STATE OF WASHINGTON
DEPARTMENT OF ECOLOGY

RE: LP-24-00002

Thank you for the opportunity to comment on the Notice of Application for the **Nelson View LLC**. We have reviewed the application and have the following comment.

NELSON VIEW PLAT PREPARED FOR NELSON VIEW LLC A PORTION OF THE SOUTHEAST QUARTER OF SECTION 20 TOWNSHIP 20 NORTH, RANGE 14 EAST, W.M. KITITITAS COUNTY WASHINGTON		
DWN BY	DATE	JOB NO.
DLP/GW/DBM	03/2024	230165
CHKD BY	SCALE	SHEET
DLP/DBM	1"=200'	2 OF 2

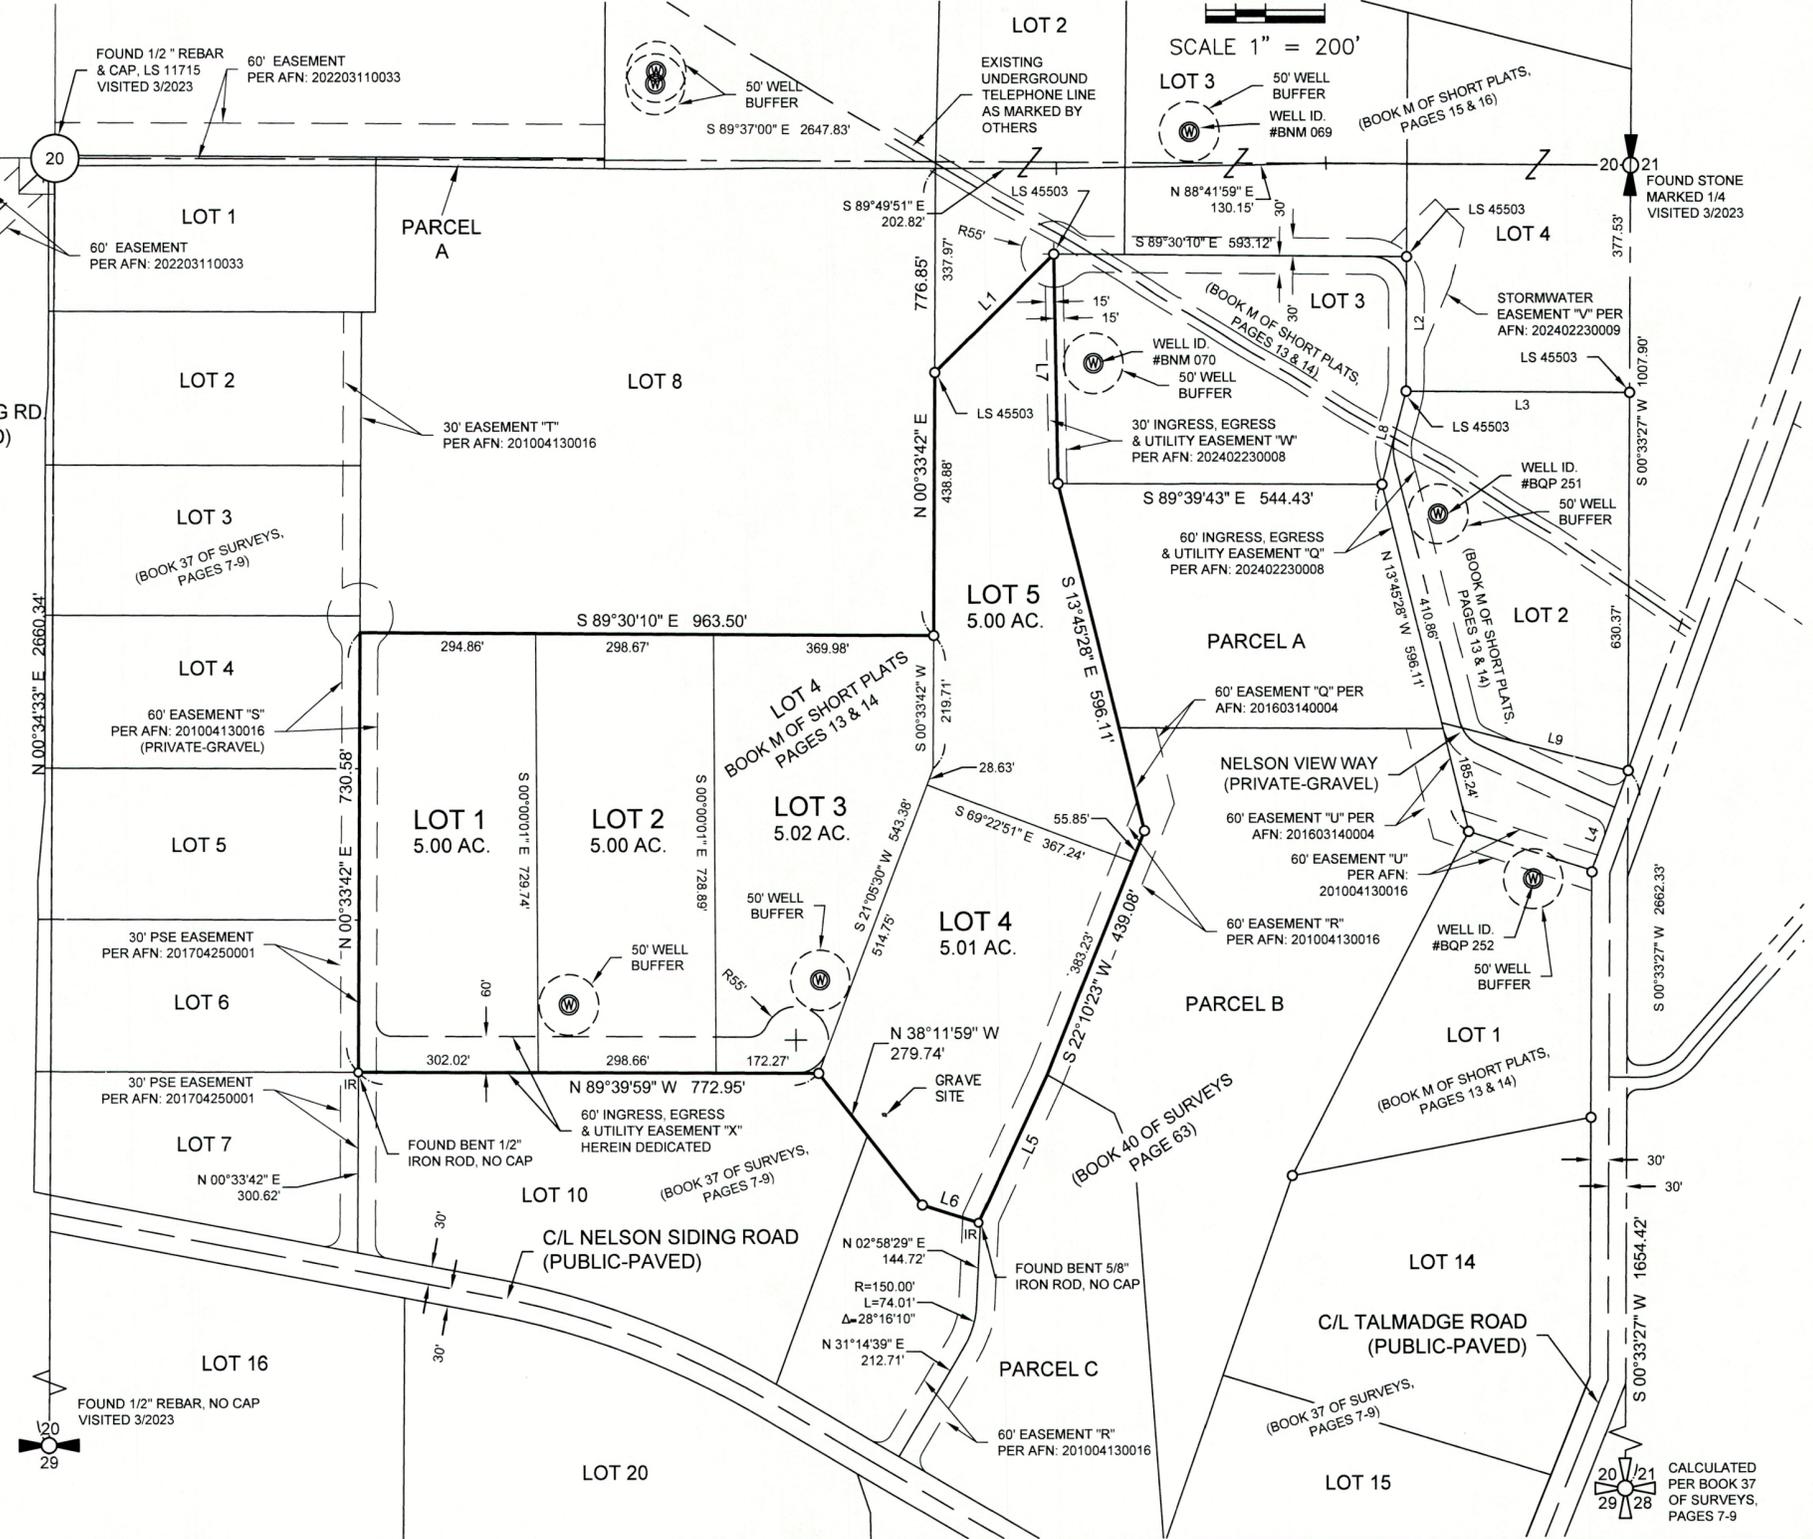
The proposal shows future development of a road near the southern border of the parcel. This road, potentially, runs through an area that has been identified as a potential wetland area by the National Wetland Inventory and Kittitas County Planning GIS data. Additionally, along the eastern portion of the property, LiDAR imagery shows that a stream channel of some form is present. The channel appears to be a distributary of Big Creek.

Prior to ground disturbance, a wetland determination, delineation, and rating should be completed if this has not previously occurred.
